# Rezoning Transportation Analysis

Petition Number: #2022-049

**From: Jake Carpenter, PE**  
Jacob.Carpenter@charlottenc.gov  
980-221-5675

Date	Description
08-24-2022	First Review (KP)
07-27-2023	Second Review (PDM)
8-30-2023	Third Review (JP)

**CONCEPT PLAN - L-2**

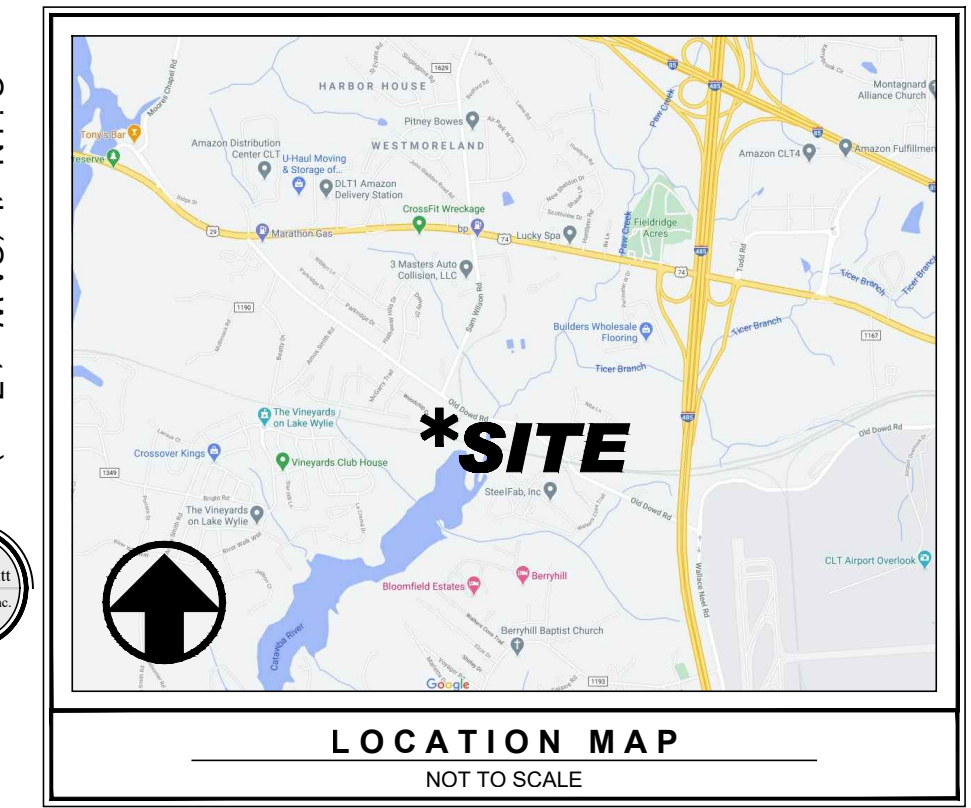
1. ~~Label and dimension the curb and gutter from the existing centerline of Old Dowd Road on the site plan.~~
2. ~~**Traffic Study:**  
A Traffic Impact Study (TIS) is not necessary for the complete review of this petition due to the site generating less than 2,500 daily trips. If during the permitting process the site generates more than 2,500 daily trips, then a traffic study will be required.~~

3. ~~Revise site plan and conditional note(s) by labeling and dimensioning the right-of-way along the site's frontage of Old Dowd Road on the site plan. The site plan shall label and dimension the right-of-way from the road centerline.~~

4. ~~Revise site plan and conditional note(s) to commit to construct an 8-foot planting strip, and 6-foot sidewalk on along the site's frontage of Old Dowd Road. The site plan shall label and dimension both items from the back of curb and gutter.~~  
~~**UPDATE TO COMMENT 7.27.2023:** Revise site plan to provide a 6ft sidewalk.~~

5. ~~Revise the site plan and conditional notes to commit to provide an 8-foot buffered bike lane along the site's frontage of Old Dowd Road. The site plan shall label and dimension the bike lane.~~
6. ~~Revise the site plan and conditional notes to commit to provide an eastbound right-turn lane, with 150-foot of storage, on Old Dowd Road at the proposed site access. Additionally, provide a westbound left-turn lane, with 150-foot of storage, on Old Dowd Road at the proposed site access.~~

7. ~~Revise the site plan and conditional notes to commit to connect the bicycle and pedestrian infrastructure, along the site's frontage of Old Dowd Road, to the adjacent bicycle and pedestrian infrastructure associated with RZP 2021-257.~~

9. ~~A site plan note(s) specifying dedication and fee simple conveyance of all rights-of-way to the NCDOT before the site's first building certificate of occupancy is issued as needed. CDOT requests rights-of-way set at 2' behind back-of-sidewalk where feasible.~~

11. ~~Revise site plan and conditional note(s) to place the proposed pedestrian infrastructure, along the site's frontage of Old Dowd Road, outside of the right-of-way within a public access easement.~~

12. ~~**NEW COMMENT 7.27.2023:** Revise southbound approach laneage to thru right lane with dedicated left turn lane. If the lane configuration remains right lane with thru left the proposed driveway stem needs to match so the signal can run without split phase operation.~~

13. ~~**NEW COMMENT 7.27.2023:** Add conditional note committing to the right turn lane on Old Dowd Road shown on the site plan.~~

14. ~~**NEW COMMENT 7.27.2023:** Extend driveway stem per markup below.~~

~~**UPDATE TO COMMENT 8.30.2023:** Driveway stem cannot be lengthened due to buffer.~~
